Ribble Valley Borough Council
Council Offices
Church Walk,
Clitheroe
Lancashire
BB7 2RA

Phone: 0300 123 6780
Email: developeras@lancashire.gov.uk
Your ref: 3/2025/0710
Our ref: 3/2025/0710/HDC/KW
Date: 15 December 2025

Location: Blue Bell Farm Higher Road Longridge PR3 2YX
Proposal: Permission in Principle for the residential conversion of an existing building to a single dwelling. No non-residential development is proposed.
Grid Ref: 363008 438982

Location Plan

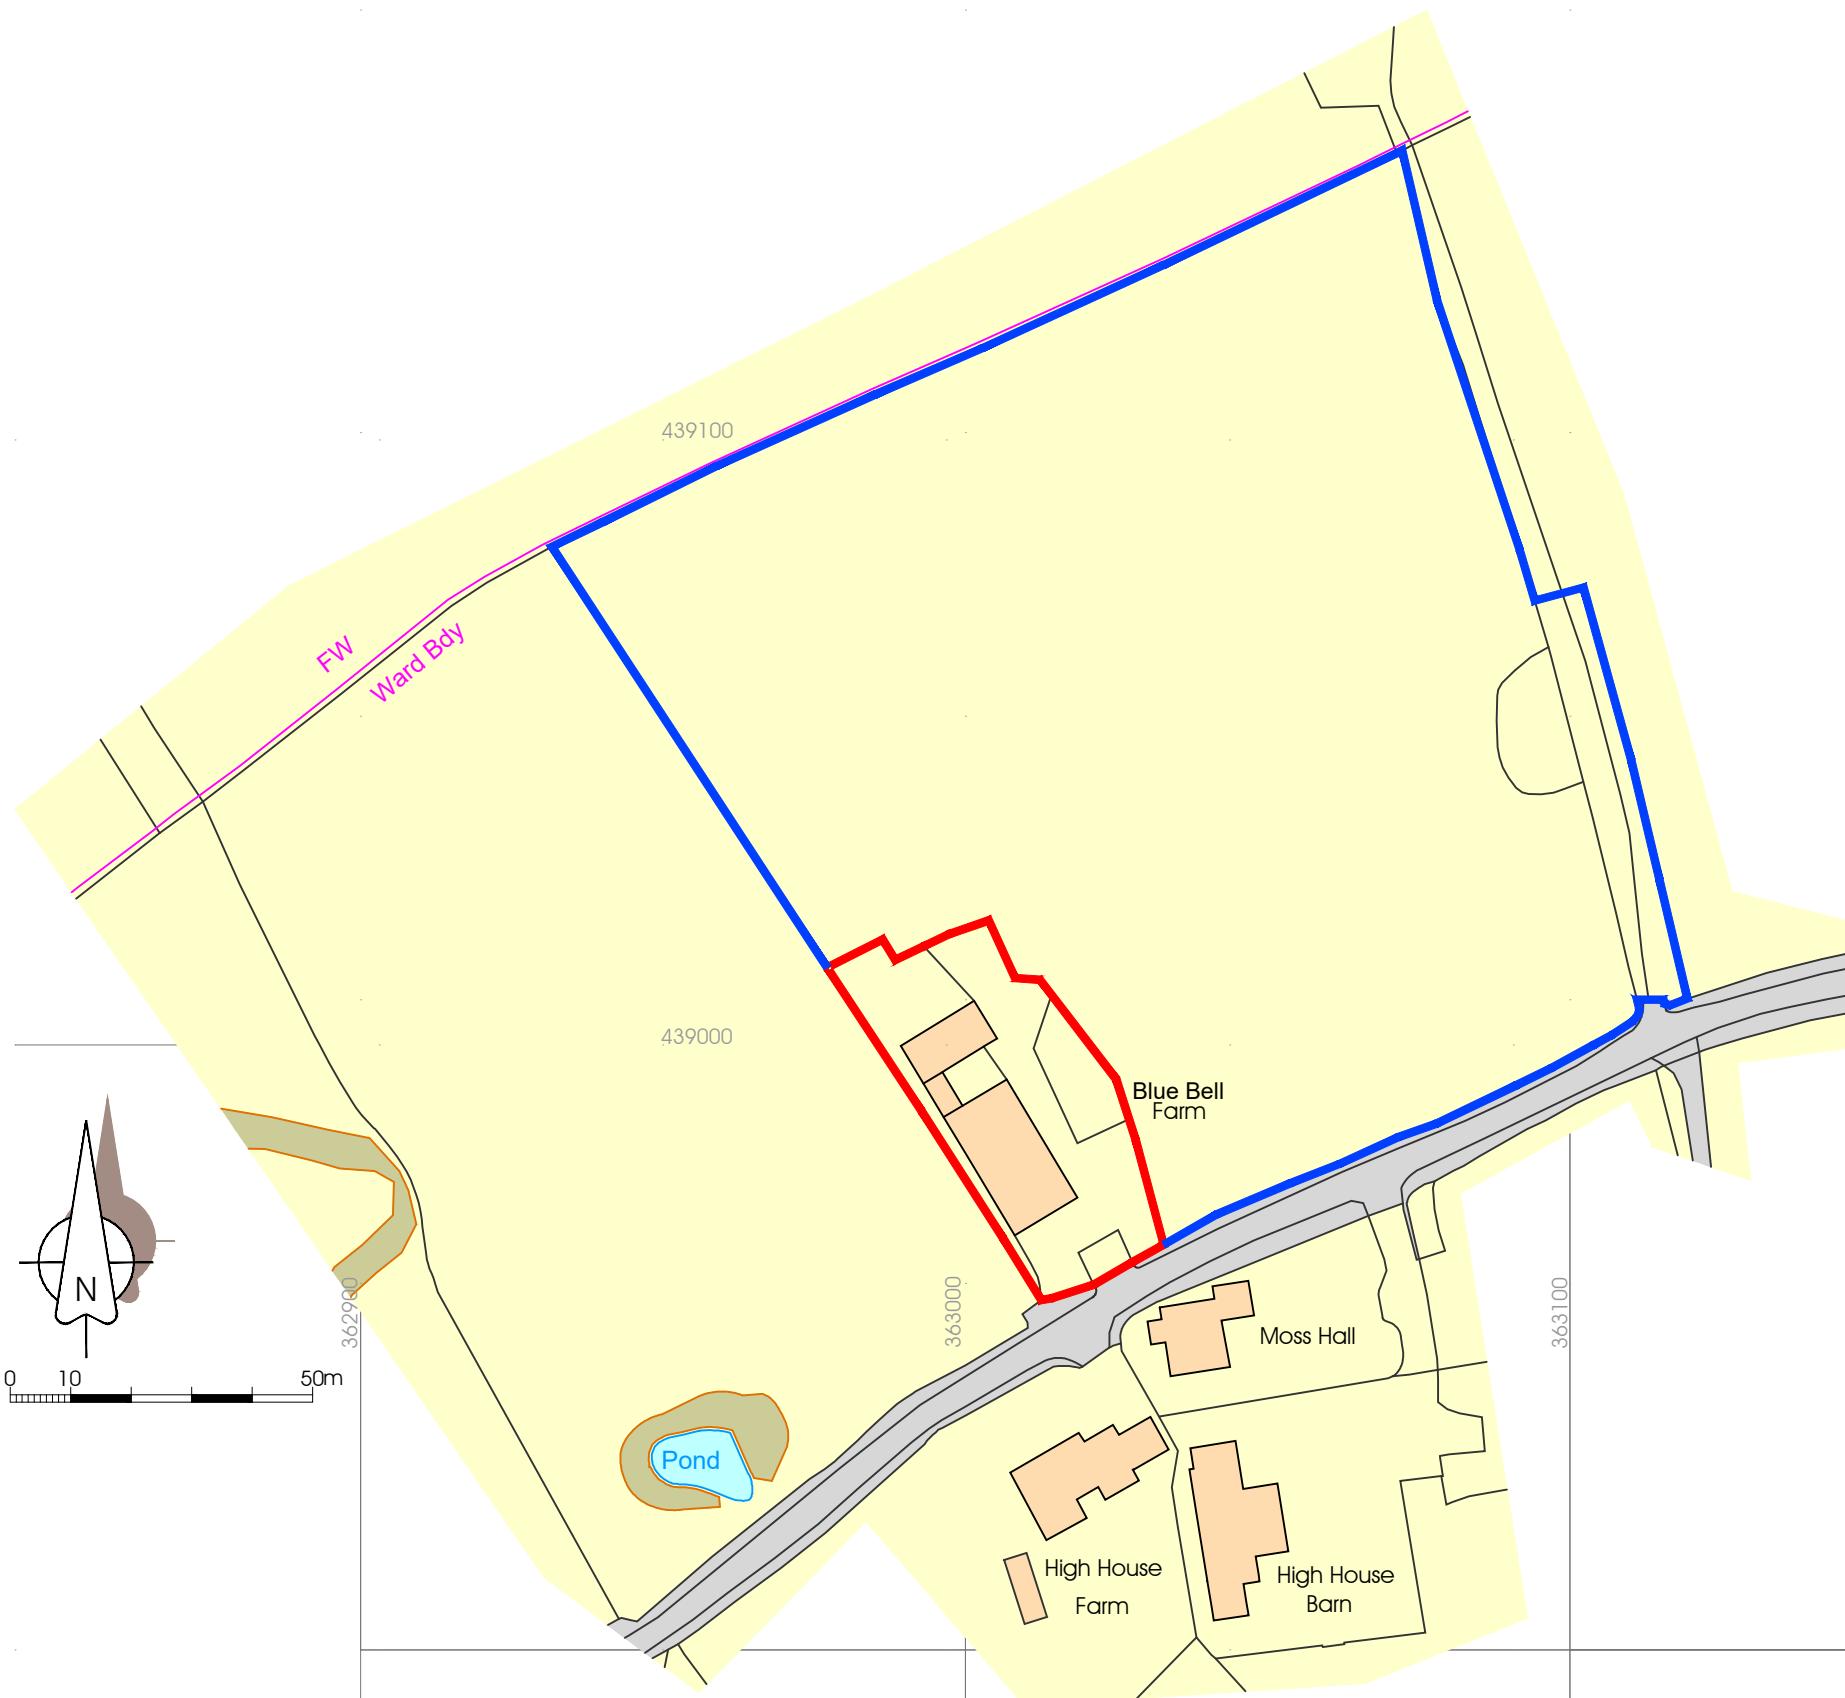
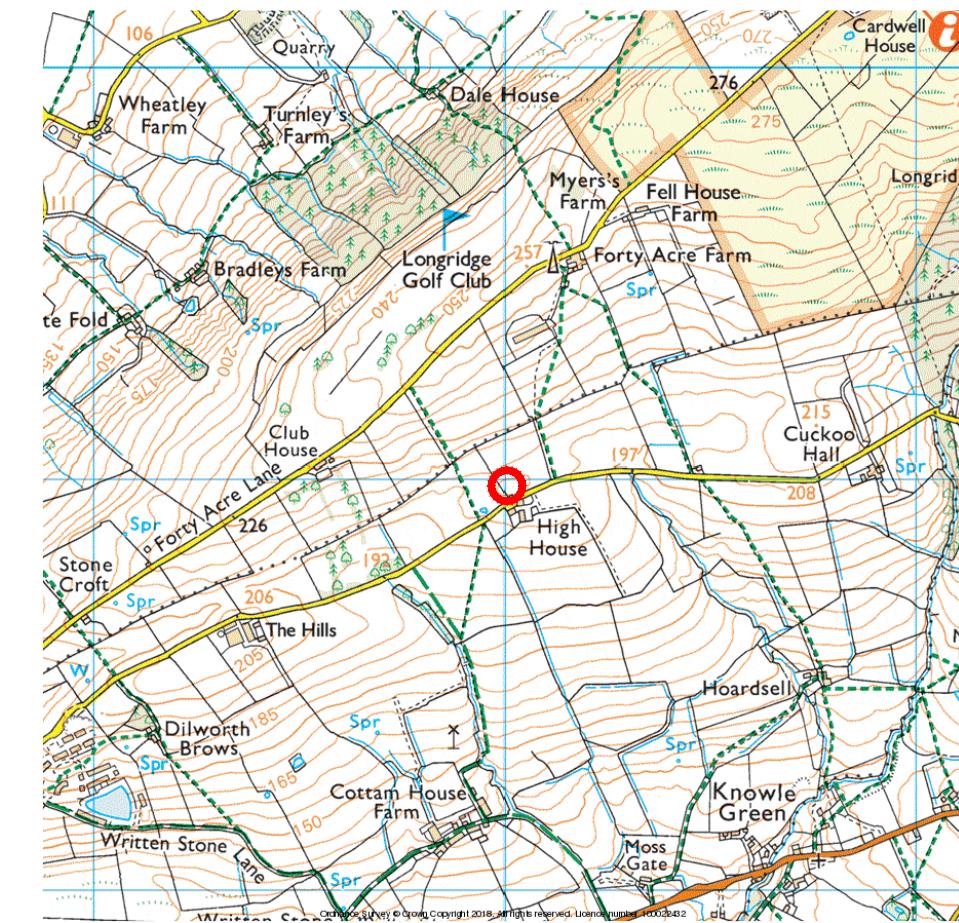
The site has accessed via an existing access onto Higher Road, an unclassified road with a national speed limit fronting the site access. The LHA is of the view that the proposal will result in a reduction of vehicle movements than what already exists given the sites approved use.

The transport note states that at the existing access '*a visibility splay of 2.4 metres by 128 metres can be achieved to the east, whilst a splay of 2.4 metres by 110 metres can be achieved to the west*'. The traffic count undertaken provided evidence that the 85th percentile of vehicle speeds were 37.8mph eastbound and 36.1mph westbound, requiring a visibility splay of 92 metres to the east and 87 metres to west.

This shows that the current access can achieve acceptable visibility splays in line with the results of the traffic count. It is likely that the vegetation which sits on either side of the access will require removal or a reduction in height to 1m in order to support clear visibility for those exiting the site, and the LHA will request this at the technical consent stage.

Should the applicant wish to amend the positioning of the access, then visibility splay to east of 2.4m by 92 metres and to west of 2.4m by 87 metres should be provided.

The LHA are of the view that the current access is an appropriate width to serve a single dwelling, at least 3.2m wide. However, the access must be properly consolidated and surfaced in bound porous materials (not loose stone, gravel or grasscrete) for 5m behind the carriageway edge to prevent debris from being dragged onto the highway. Given that the access slopes towards the highway, surface water drainage should be provided at the access to ensure water is not discharged onto the highway.
